ENG-SF22023-R1-CDs.pdf Markup Summary

[24 sheets total with utility plans]
PCD FILING NO.
PAGE 20-005 (FALCON MEADOWS AT BENT NEIGHBORHOOD REGULATORY PLAN)
PC-20-005 (FALCON MEADOWS AT BENT NEIGHBORHOOD REGULATORY PLAN)

Cursory comments

ROAD IMPROVEMENT PLANS

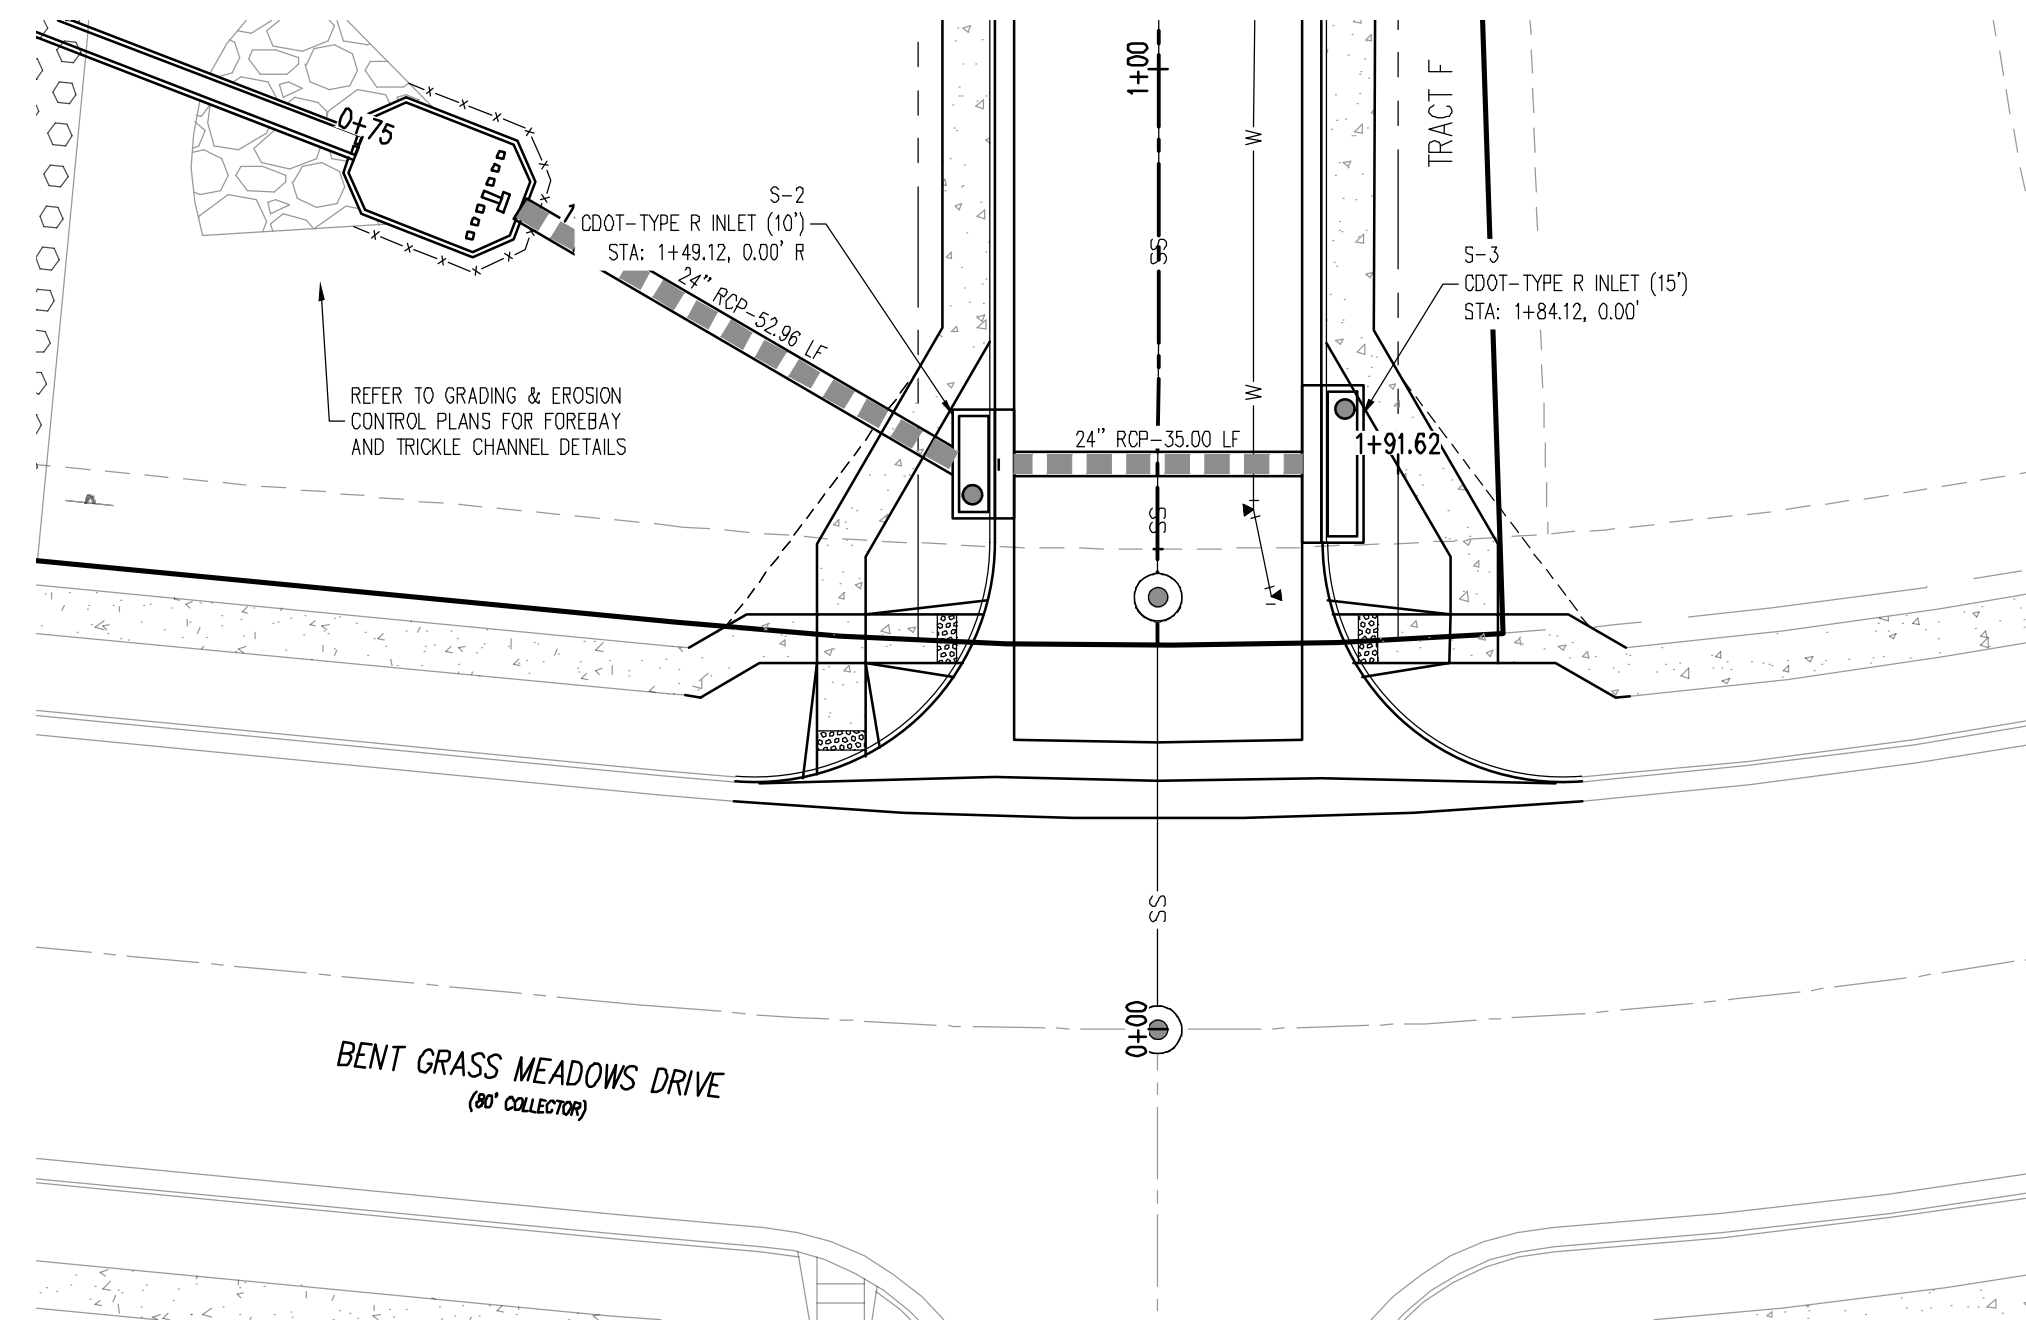
Call out crosspans and per SD_2-26

Show and label the existing 3% grade; revise design as appropriate

Show and label the existing 3% grade; revise design as appropriate

**STORM DRAIN PLAN & PROFILE**

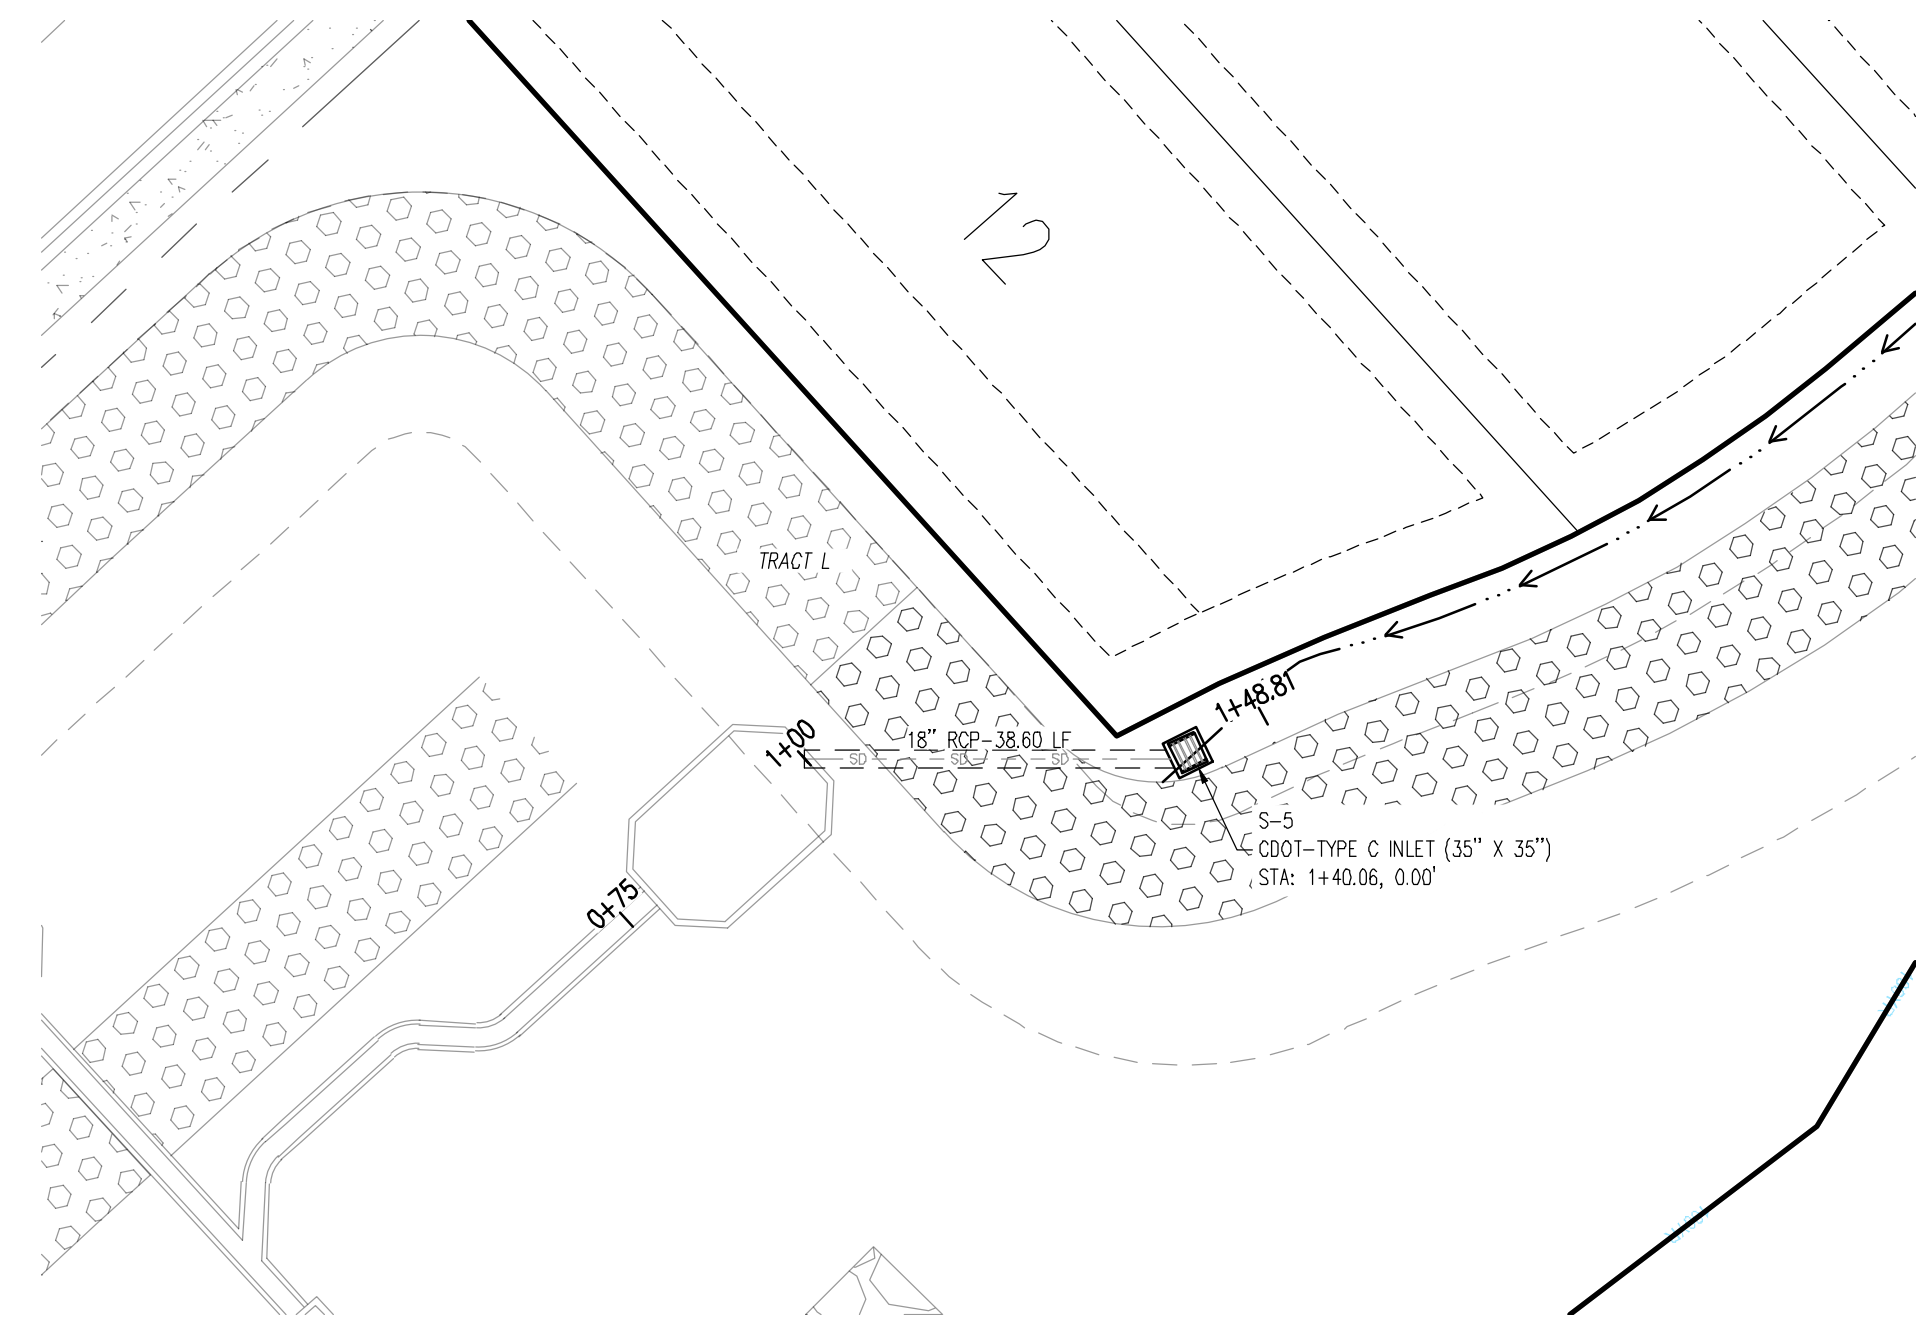
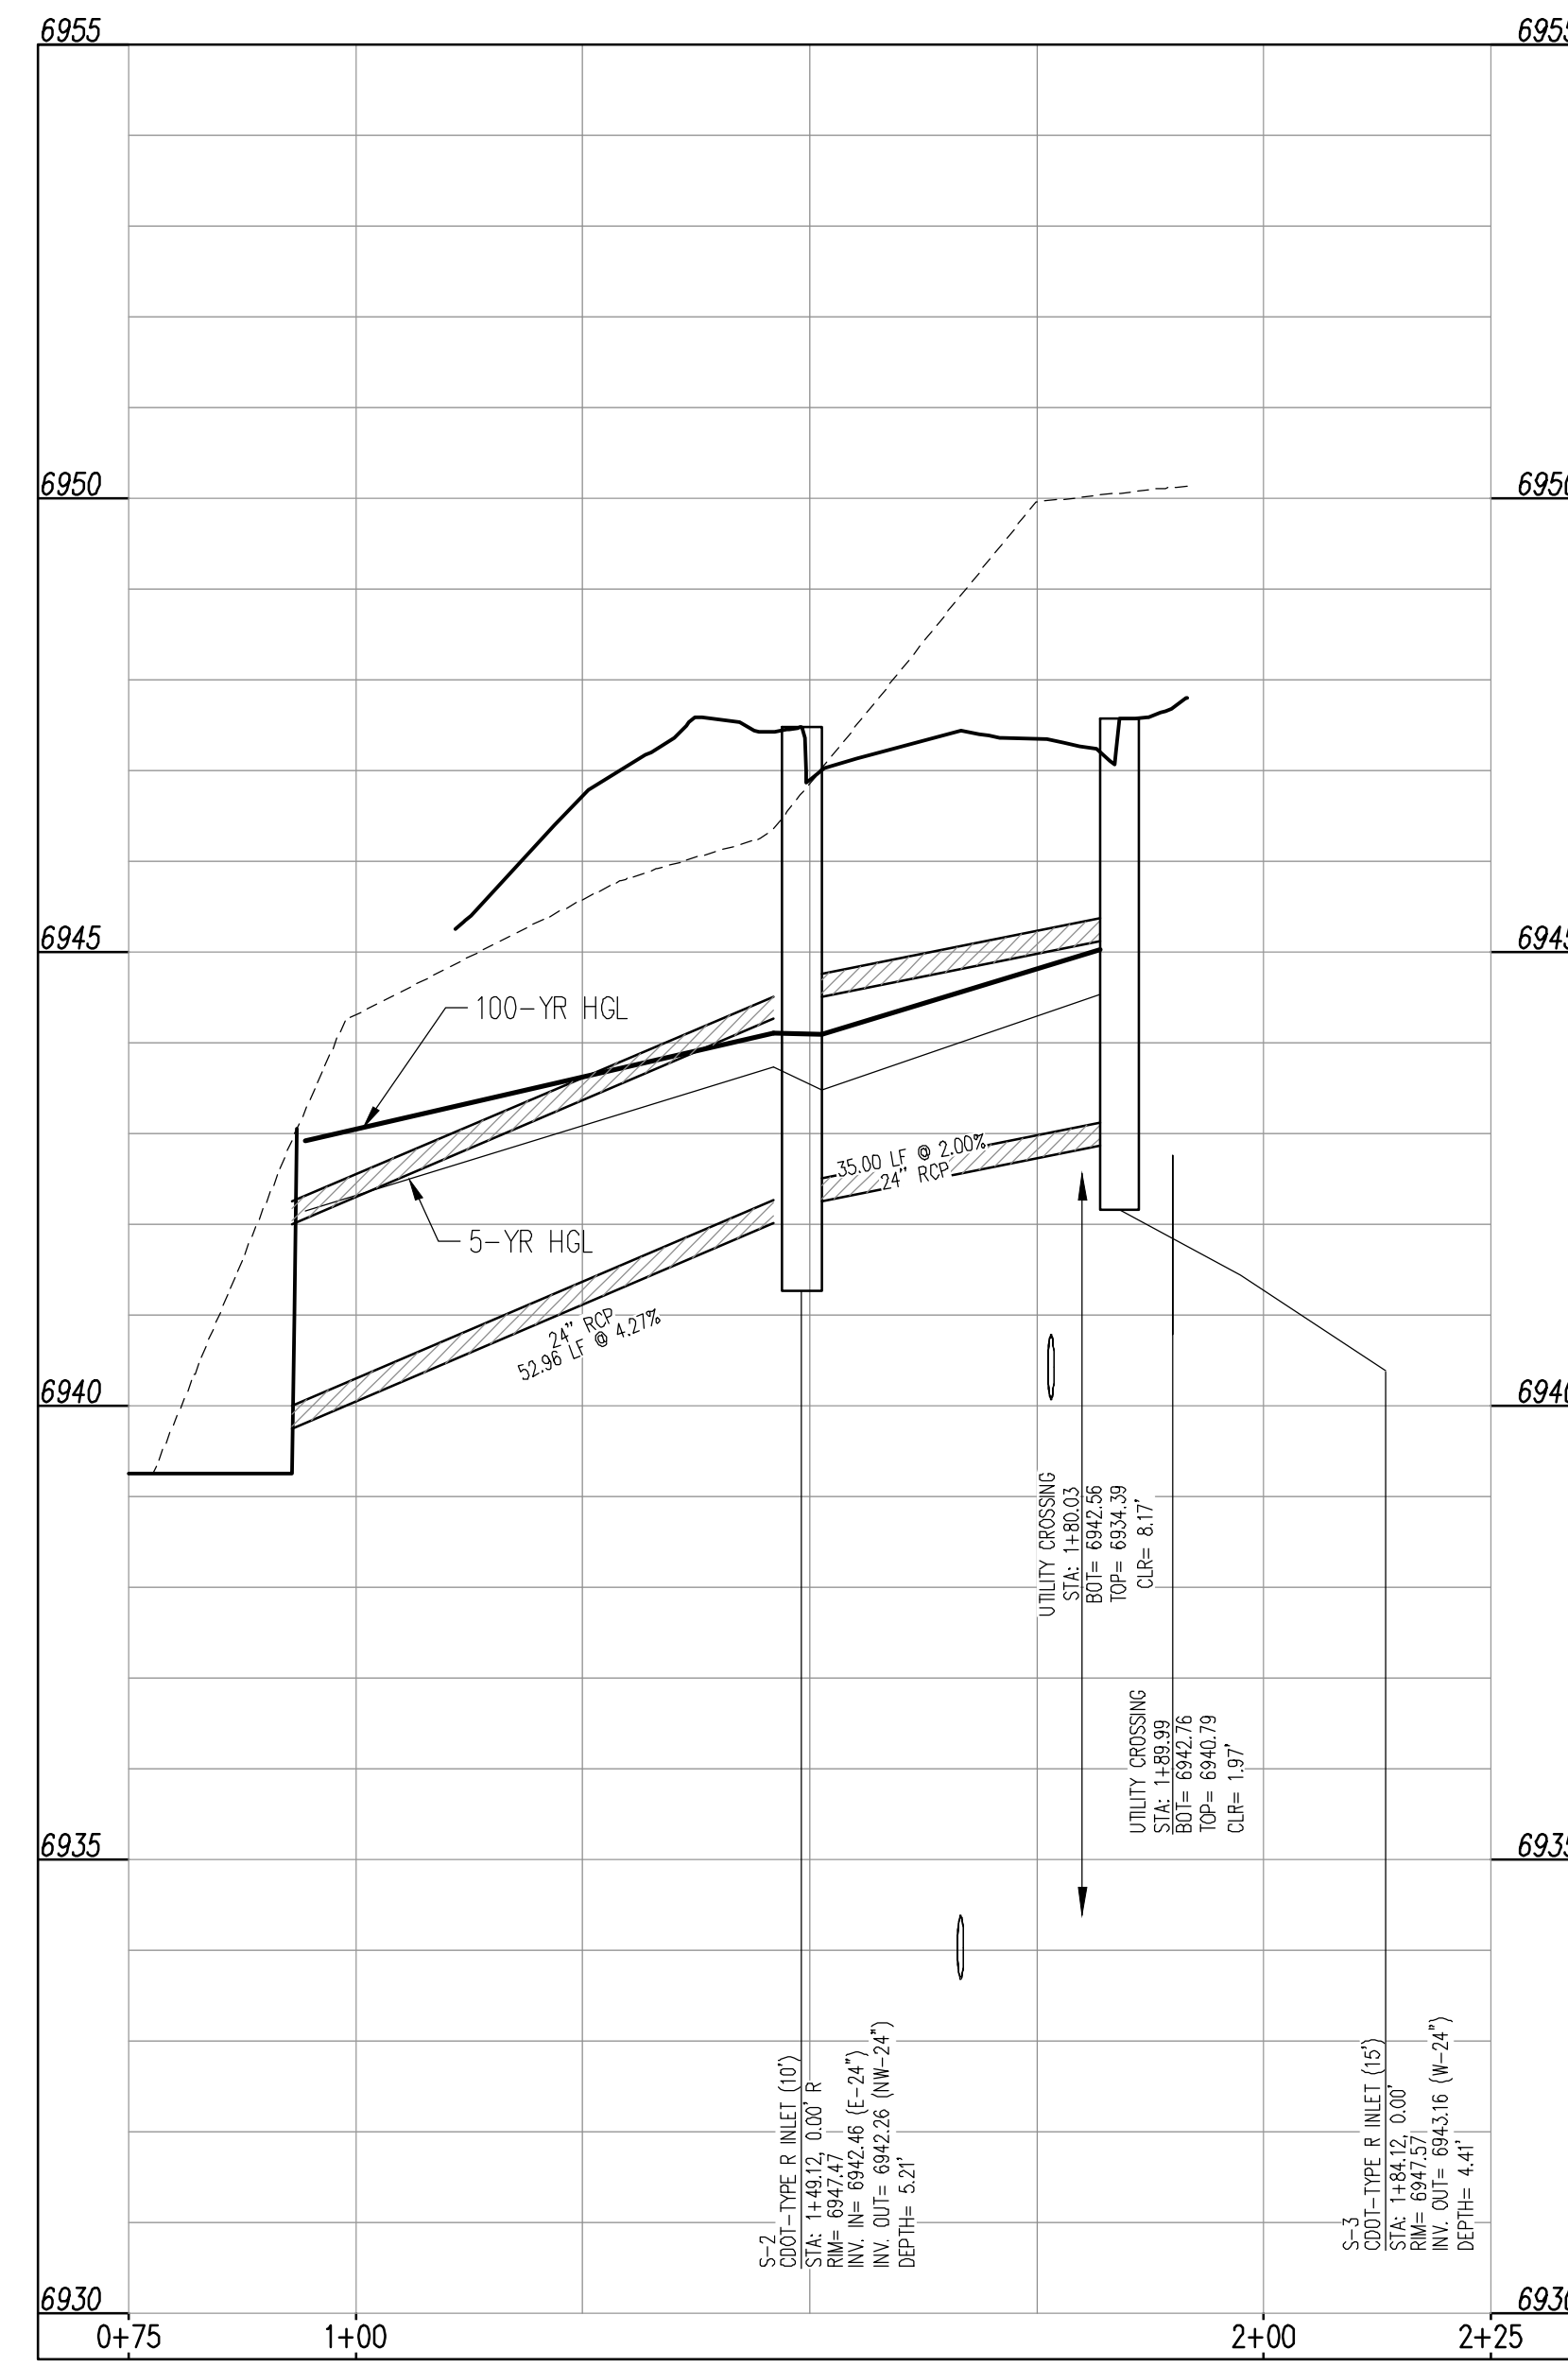
Show and label HGL and Q5 and Q100

Show forebay
